February 1, 2023

RE: Responses to Comments
Dutch Bros. Coffee
Near the SWC of Gibson Boulevard. S.E. and Yale Boulevard S.E., Albuquerque, New Mexico
87106
Our Job No. 22212

We have revised the plans and technical documents for the above-referenced project in accordance with your comment letter dated December 21, 2022. Enclosed are the following documents for your review and approval:

Title:  
EROSION AND SEDIMENT CONTROL PLAN  
SWC GIBSON BLVD AND YALE BLVD  
ALBUQUERQUE, NM 87121

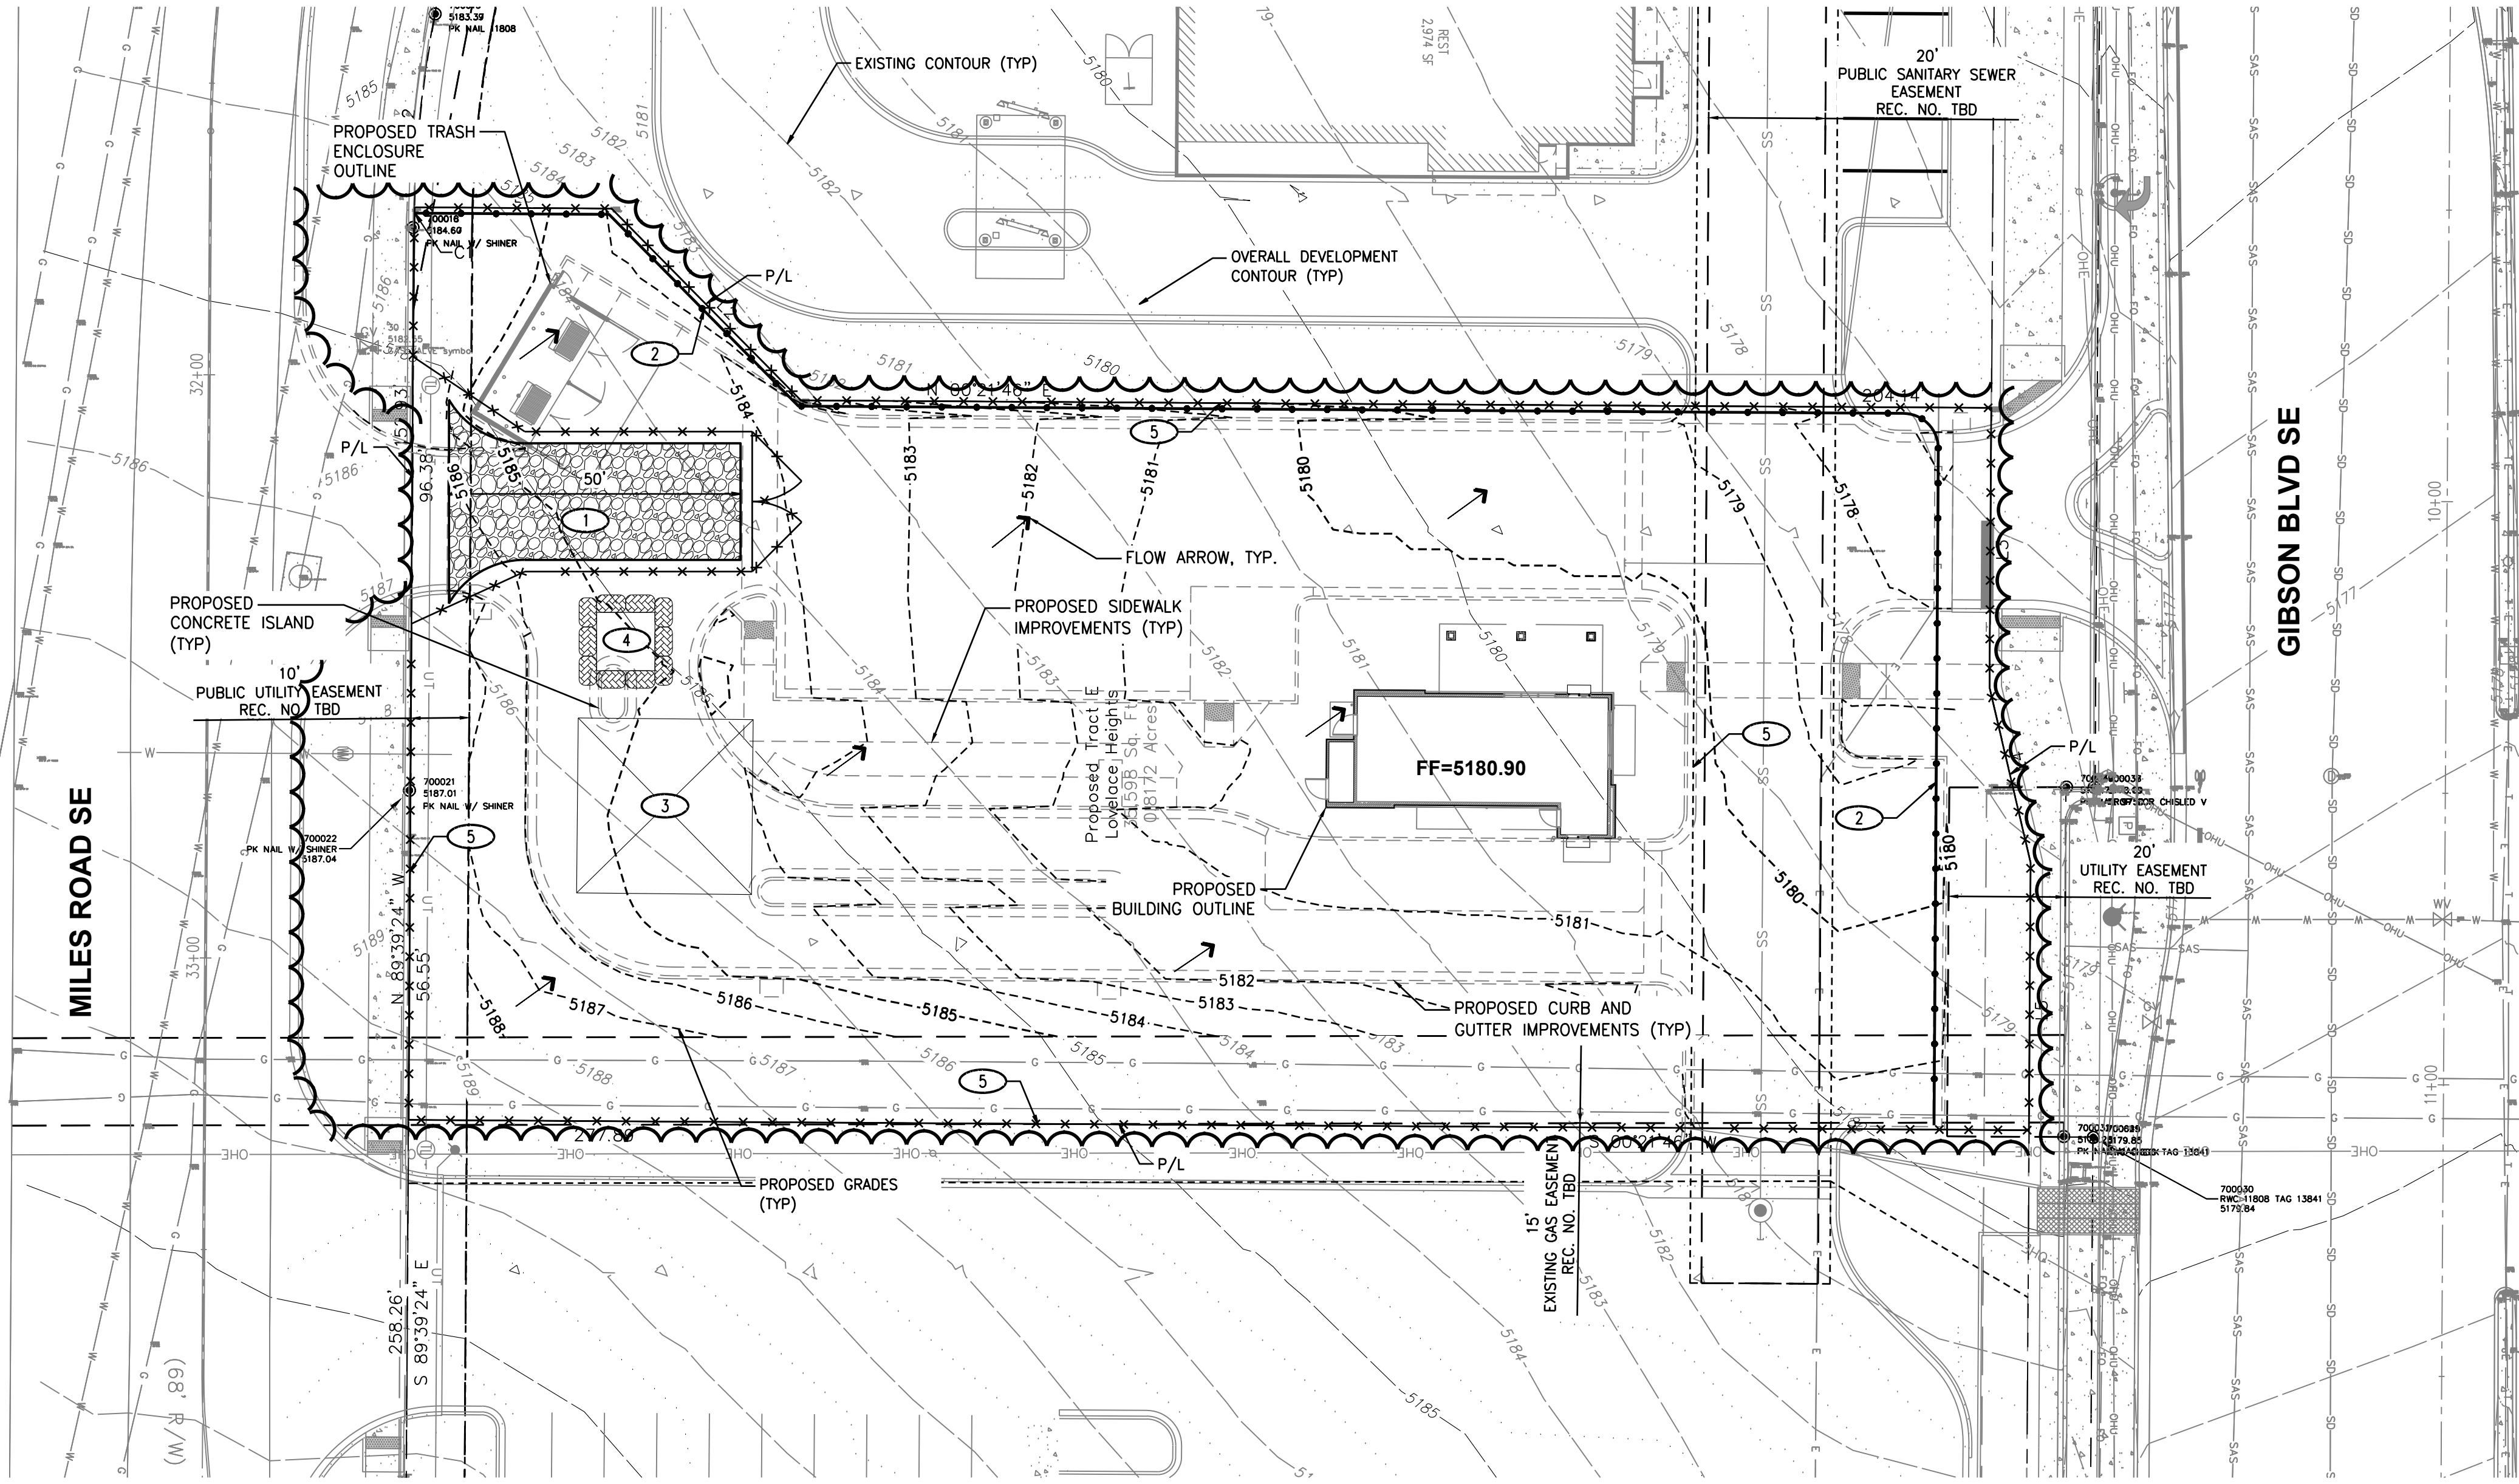
1. *The ESC Plan can't be approved until after Hydrology approves the G&D Plan. The existing and proposed grades must be shown on the ESC Plan, and they must agree with the Grading Plan approved by Hydrology (CGP7.2.4.b.ii).*

2. *Show all structures on the ESC Plan including the building, sidewalk, and asphalt.*

Response: The grading and drainage plans have been approved by the City of Albuquerque Hydrology Section, dated December 22, 2022. The existing and proposed grades have been included on the ESC Plan, which agree with the proposed grades submitted to Hydrology.

Response: Proposed structure improvements have been included on the ESC plan for review.
